CITY OF ALBUQUERQUE

**RE: Excess Space Storage
531 Silver Creek NW
Grading & Drainage Plan
Engineer's Stamp Date: 03/20/2025
Hydrology File: K10D023L
Case # HYDR-2025-00093**

IDO Zone Atlas May 2018

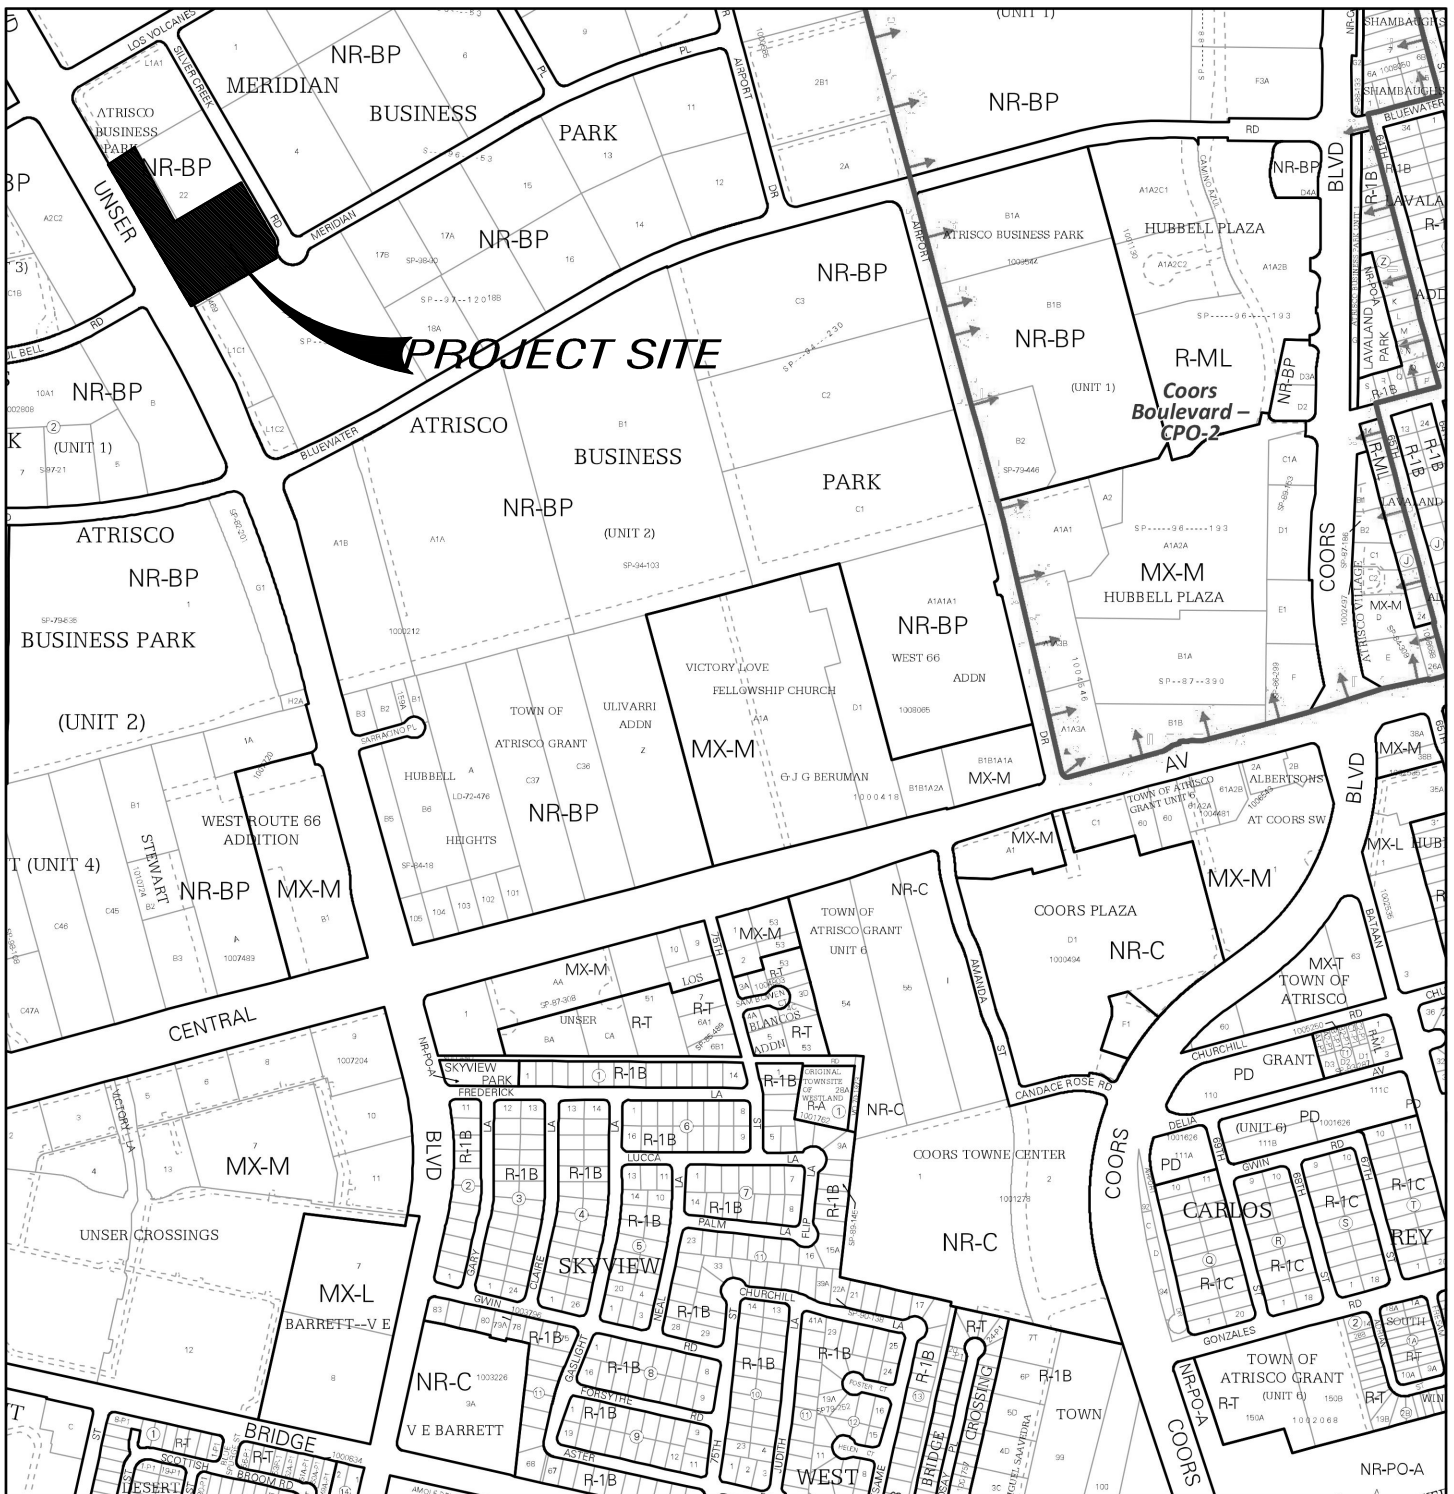
1. The highlighted area in the FIRM and Zone Atlas map do not match. Please update with the correct project area.
2. Location & Description – Please provide the correct legal description of the property.
3. An SO-19 Permit will be required and should be included on the request. Please include the [standard SO-19](#) notes on the grading plan.
4. Include project benchmark and datum.
5. Since the SWQV provided is greater than the SWQV required, please remove the cash in lieu statement but keep the calculation.
